## Planning Statement for Variation of Condition to Orchard House - October 2021

Application Number: 21/03943/FUL

Proposal: Variation of condition 2 (approved drawings) re permission 20/01200/FUL - Construction of a detached dwelling and garage and associated access.

Orchard House - Block Plan
Ref: OH_BP200_v3 Kit Franklin 26/09/2021

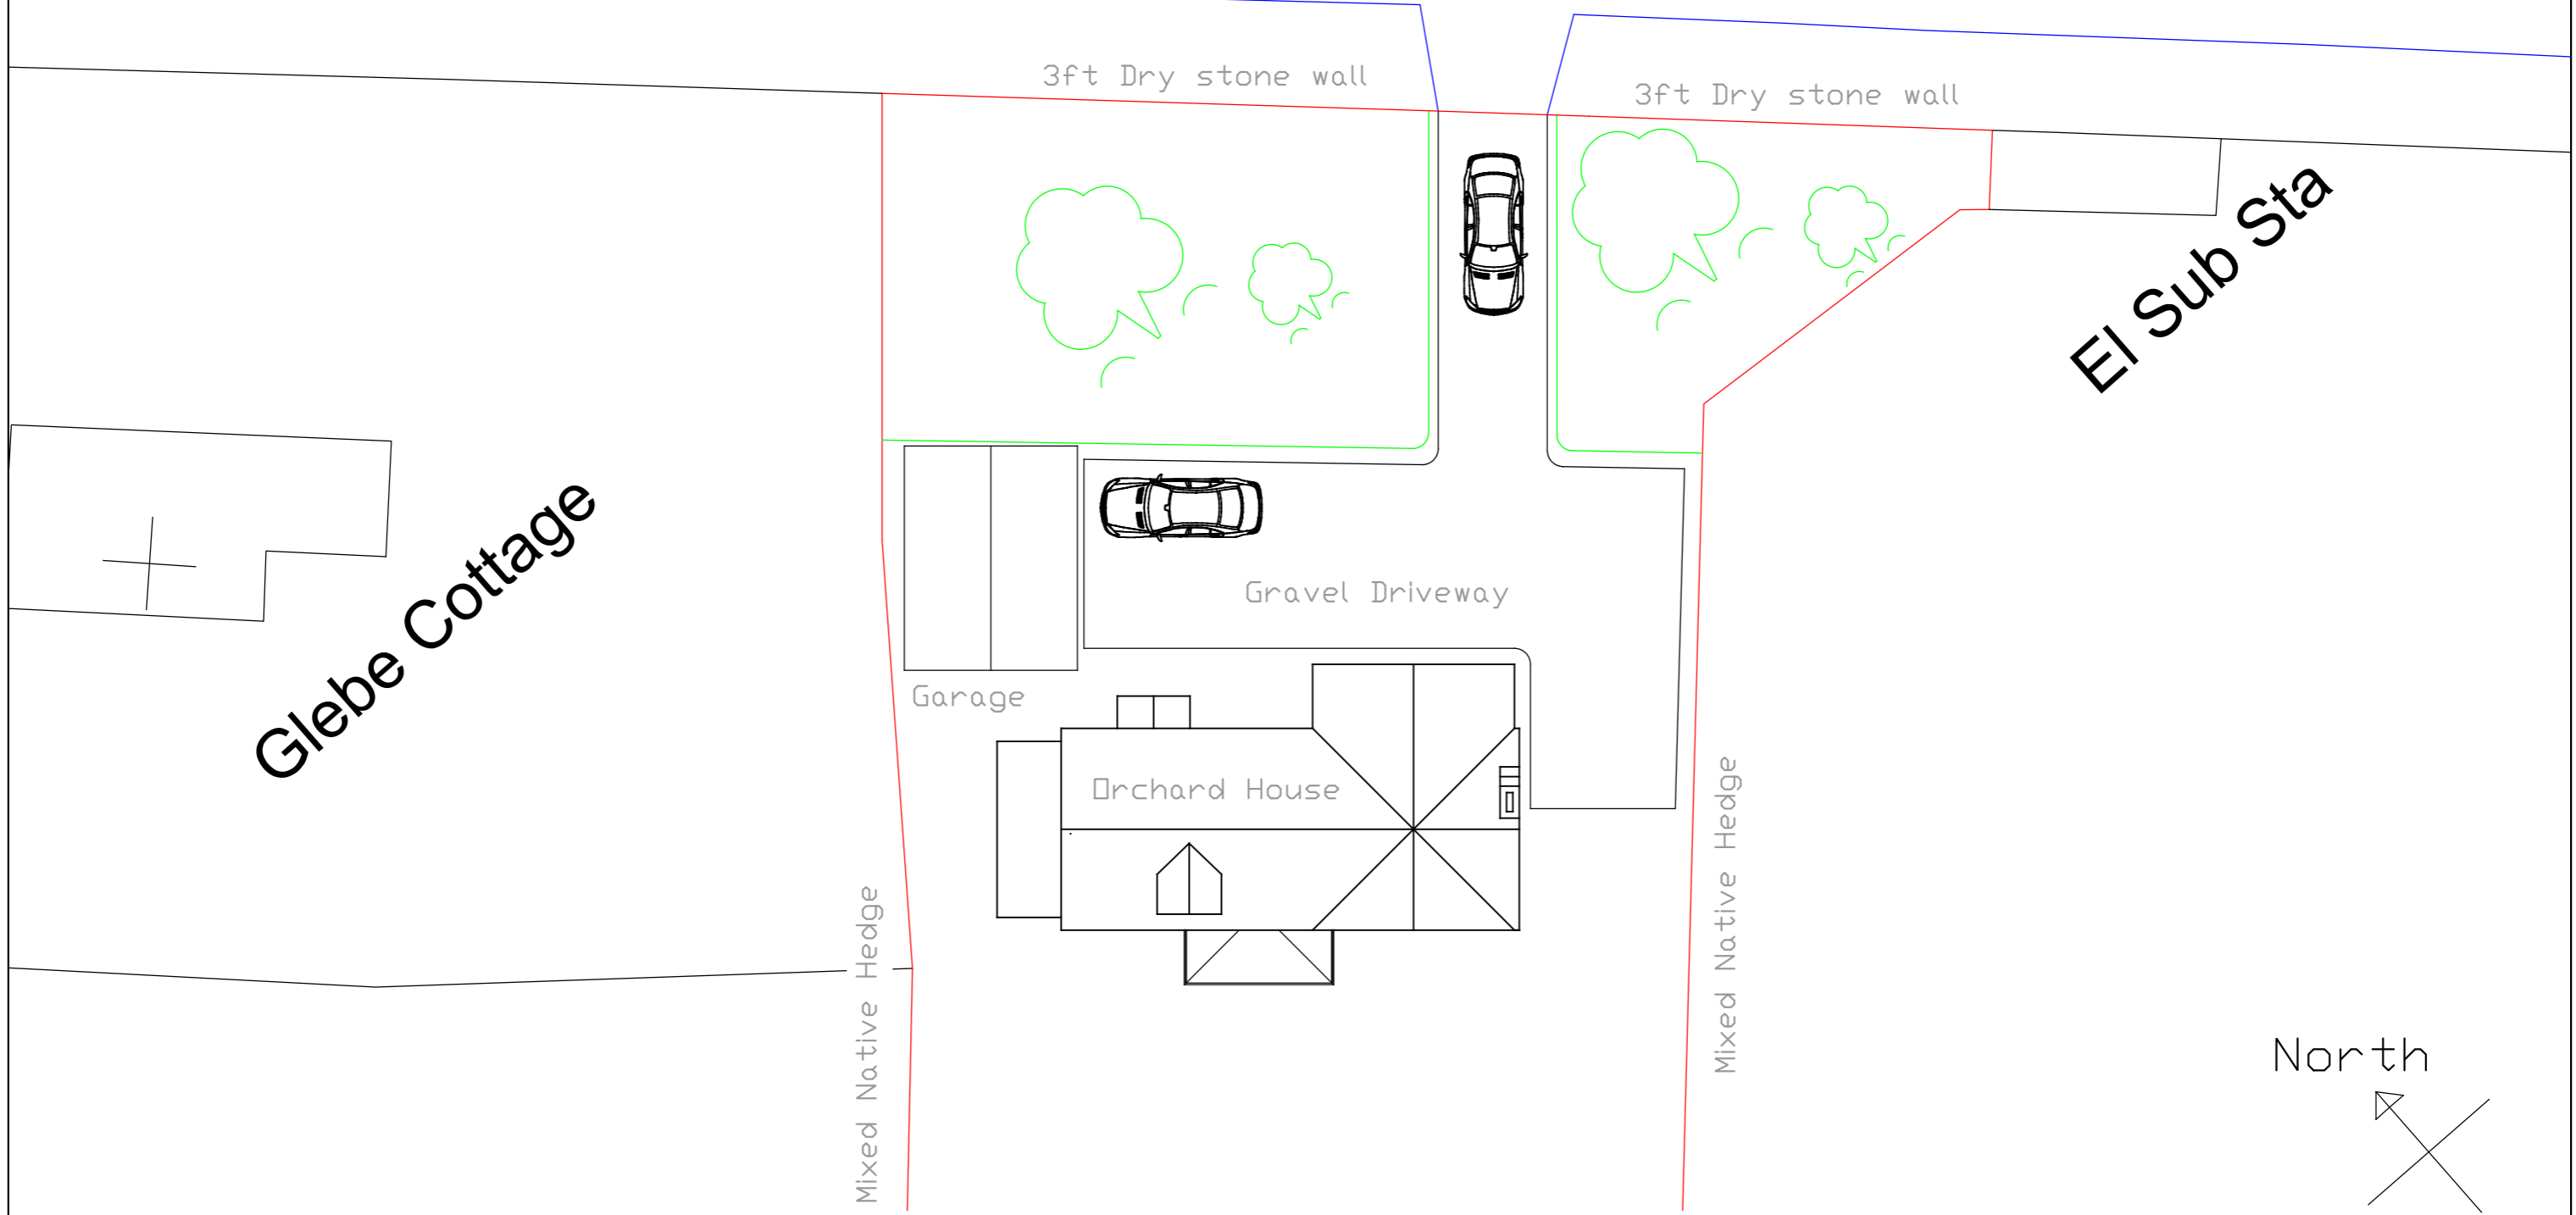
On reflection of our plans we were concerned that the living space for a four bed house was limited, in particular the kitchen which we see as the centre of a family home. The original plans allowed little space to eat and sit socially within the kitchen itself. The amended plans increase both gable width and the building length by 0.3 metres, it also adds an oak framed bay window to the kitchen on the south west elevation of the house. These modest alterations increase the size of the kitchen which allows us to have a breakfast bar as somewhere to socialise as a family, with homework and cooking being done side by side.

Furthermore, minor changes have been made to the internal layout of the first floor and loft space to improve the installation of services, with the bathrooms now being above one another.

We believe that the revised plans will have a positive contribution on the design of the house, improving the aesthetic of the south west elevation and drawing light and warmth into the kitchen while the overall size of the house still sits comfortably within the site.
